Was 03/2011/0140, now 03/2011/0559

Martin Nugent
01254 828060
D3/11/0140

**Planning Applications, Ribble Valley District
D3-11-0140 land adjacent to High Gill Barn, Tosside**

DWG -05E

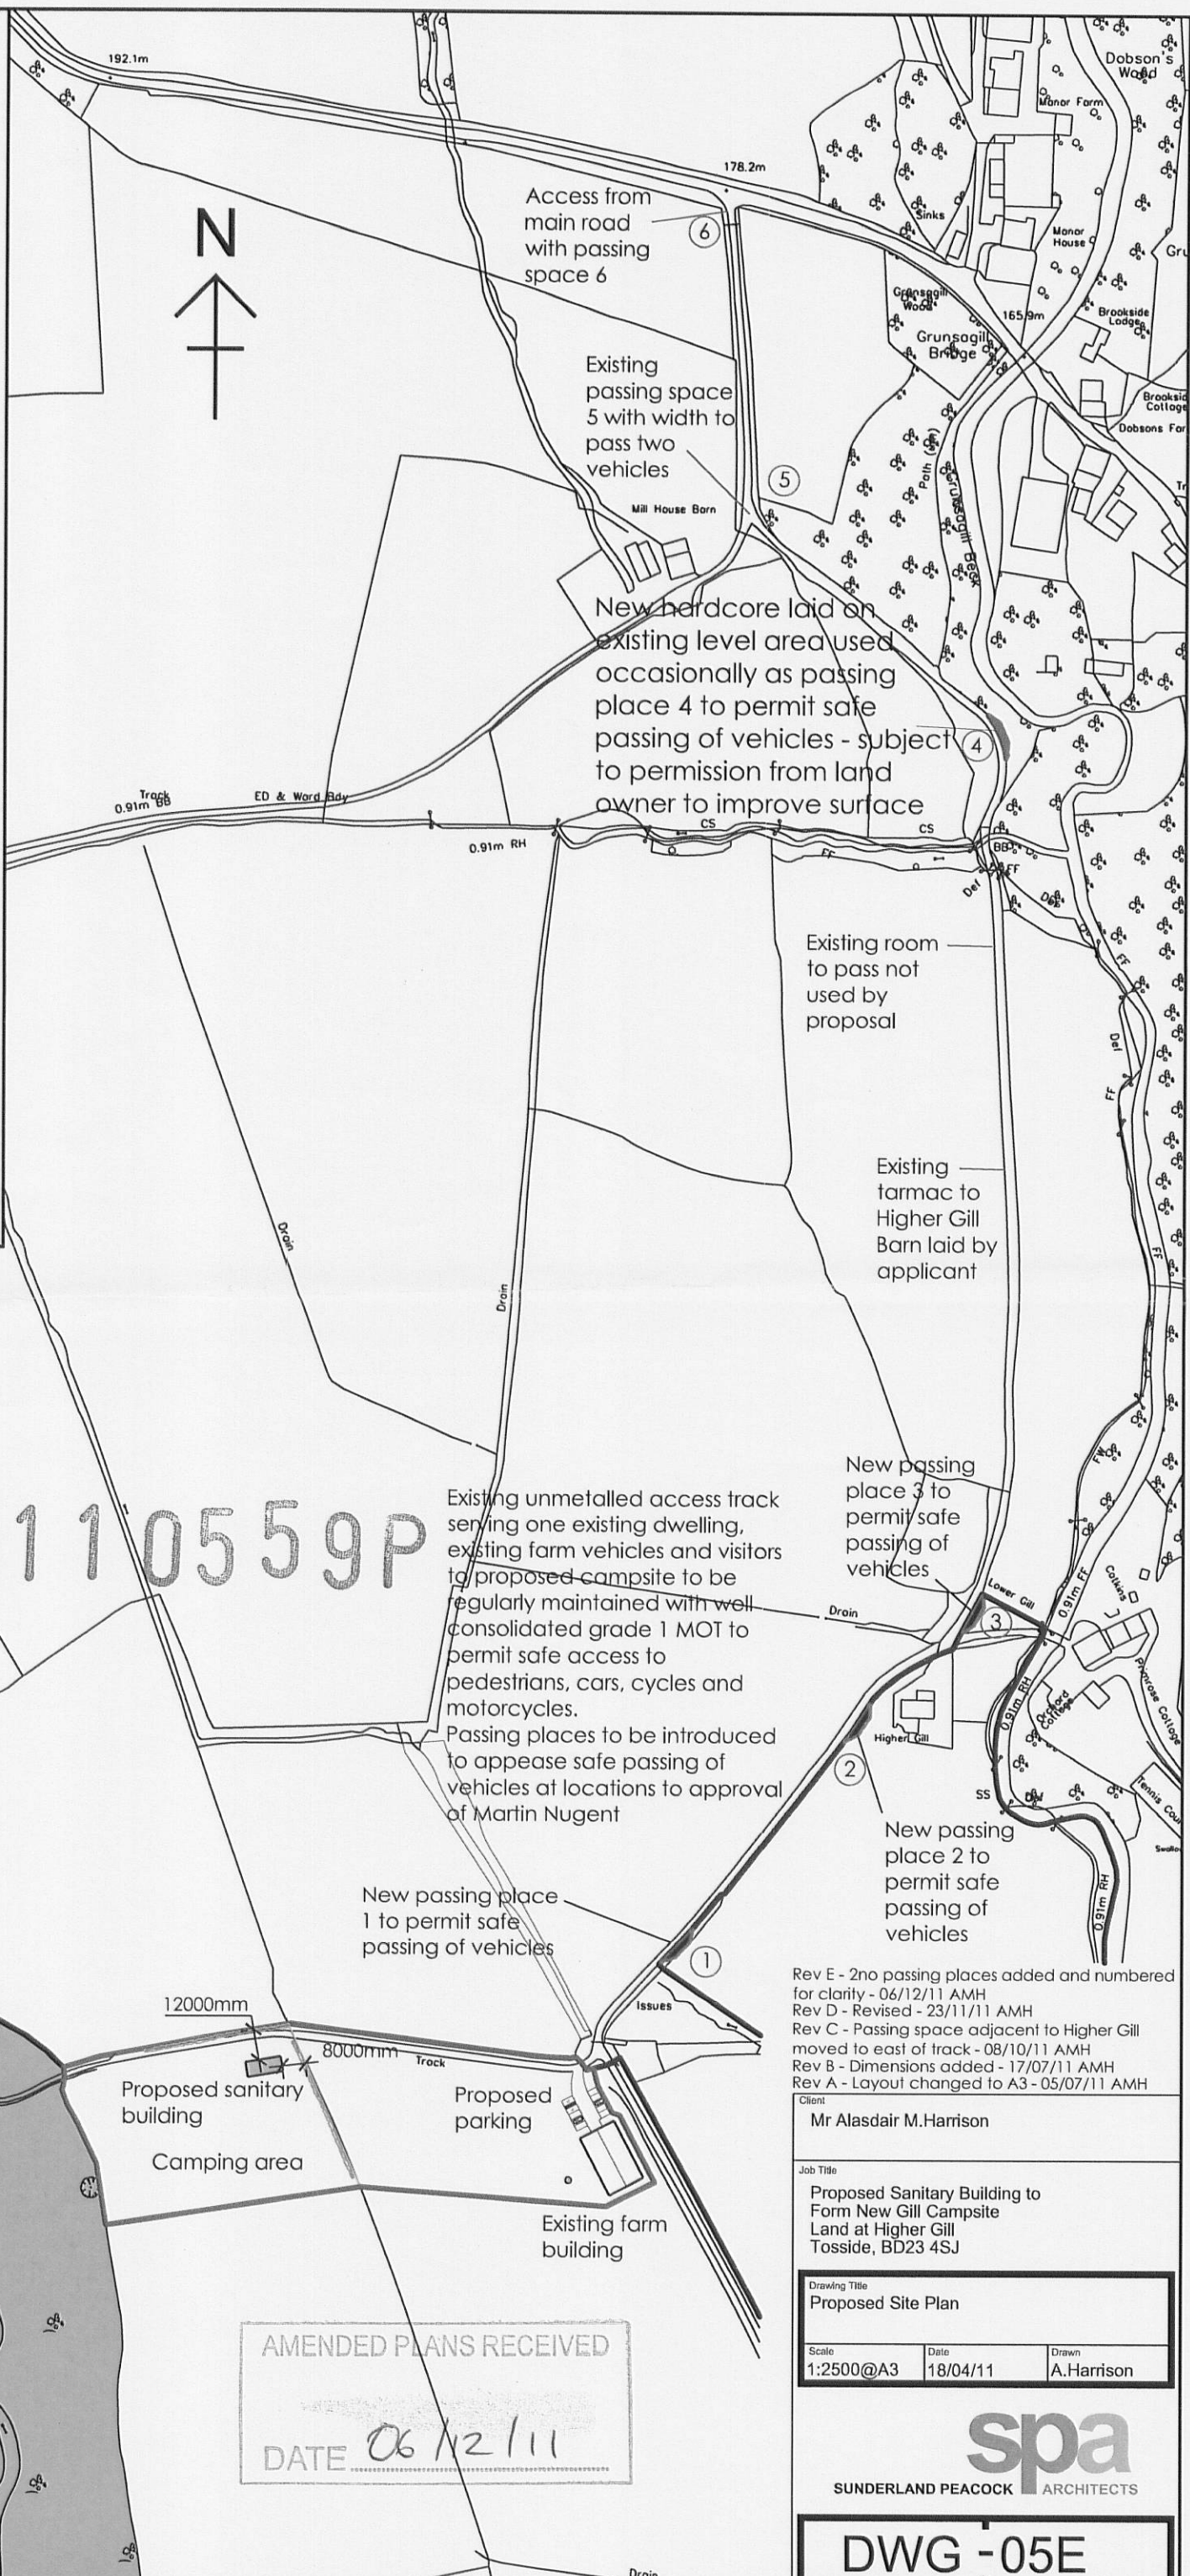
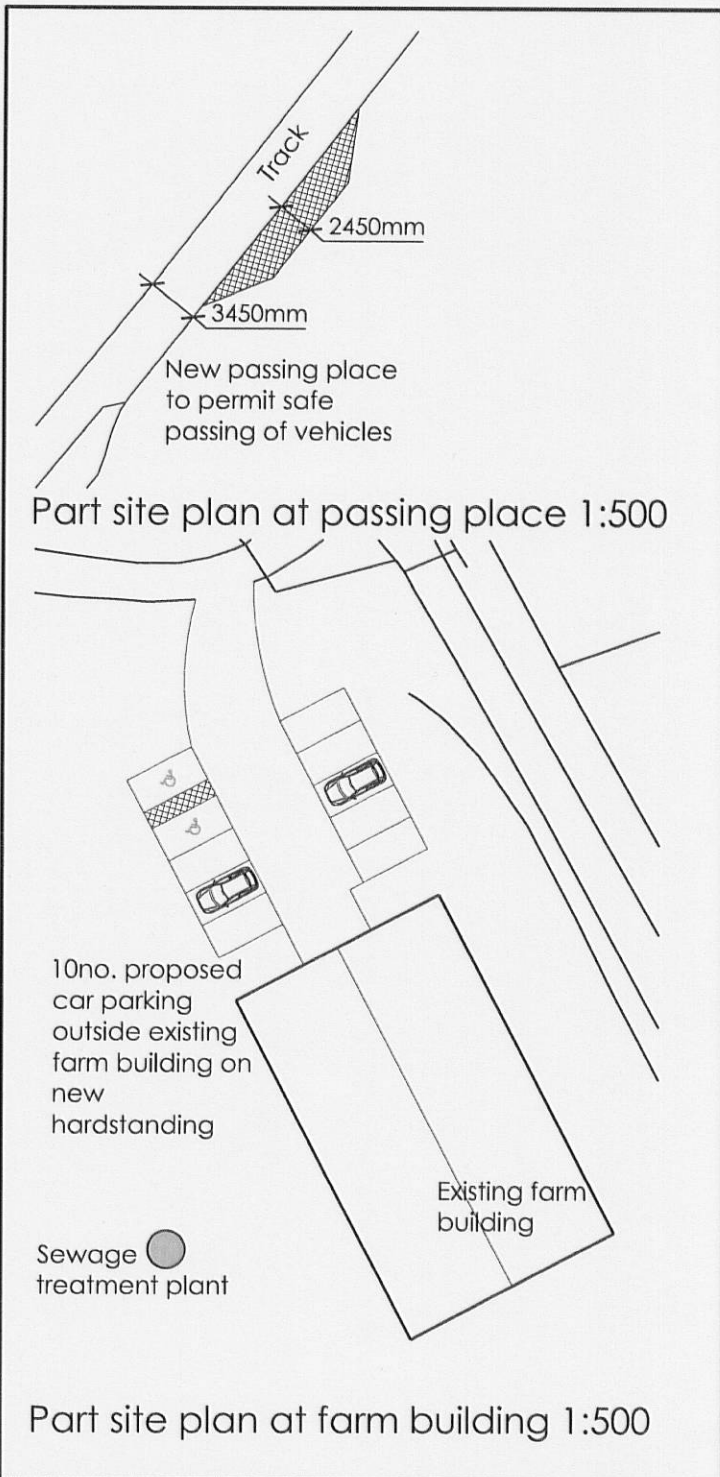
The proposed improvements to the access road, identified on Dwg-05 and dated 18 April 2011, secures significant highway safety benefits and brings this track up to a standard consistent with a route suitable for the general public. The passing places that have been identified will provide a safe means of access for the public travelling to the site.

Subject to the introduction of the highway measures as identified on the amended plans, I have no objection to this application on highway safety grounds.
